Recommendation: Approve

Applicant: Albion Land

Proposal: Non-material amendment to 22/01632/REM - vary 12 of the approved plans and drawings listed in Conditions 1, 2 and 3. Amendments to Units 8 and 9 into a single unit, along with minor changes to Units 6, 7, and 8.

6.1. The proposal is considered to be non-material and the application is therefore recommended for approval.

Drawing Title:
 RM4 - Soft Landscape Proposals
 (Sheet 1 of 4)

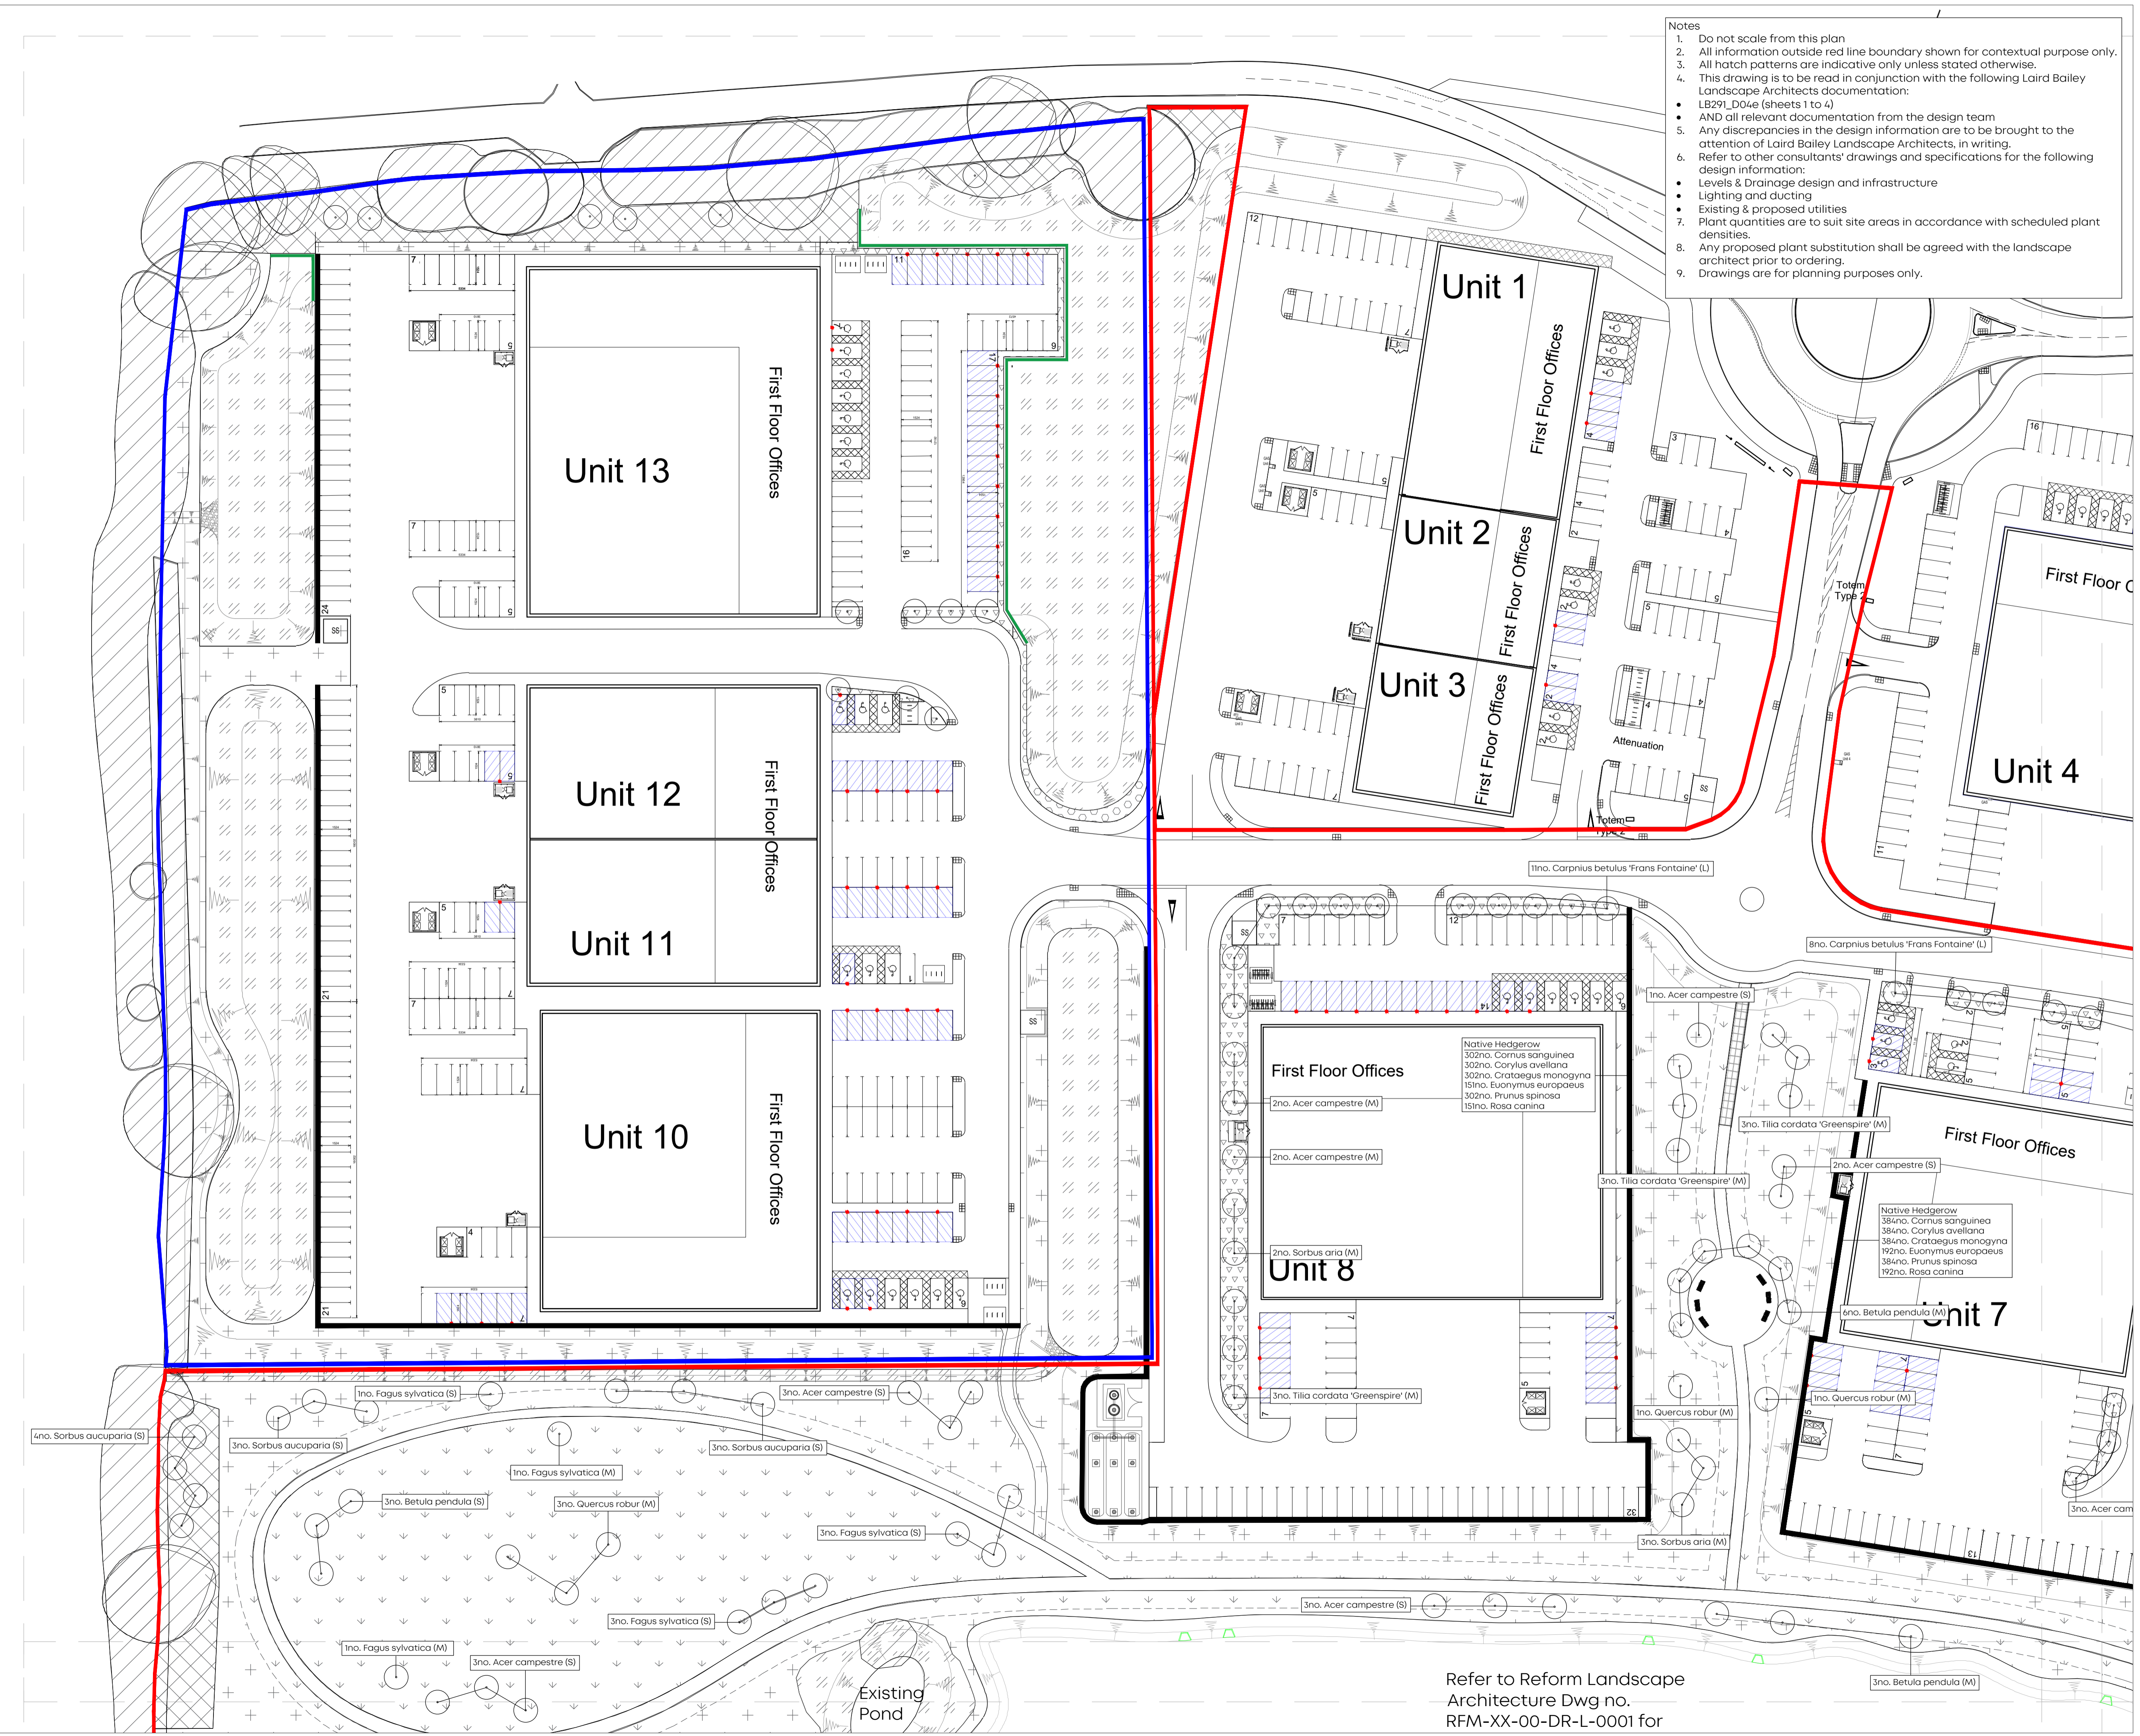
Changes have been made to the layout of car parking, cycle storage location and bin stores and EV charging spaces, to reflect the merging of Units 8 and 9 to Unit 8. The changes do not alter the overall number of parking or cycle spaces. The changes are being sought by varying conditions 1, 2 and 3 of the aforementioned reserved matters. Greater changes are proposed to the elevational design of unit 8 to reflect it as one unit rather than 2 (8 and 9 previously) – these changes are considered to be acceptable as they remain complementary to the design of the overall park and the design on some elevations as proposed now is elevated beyond that previously approved.

Due to design development, the tarmac has been extended between Units 6 and 7. The proposed alterations are considered to be minor and non-material in nature. They remain within the scope of the outline parameters and are in keeping with the design and appearance of site. This amendment is proposed under Conditions 1, 2 and 3 of the aforementioned reserved matters.
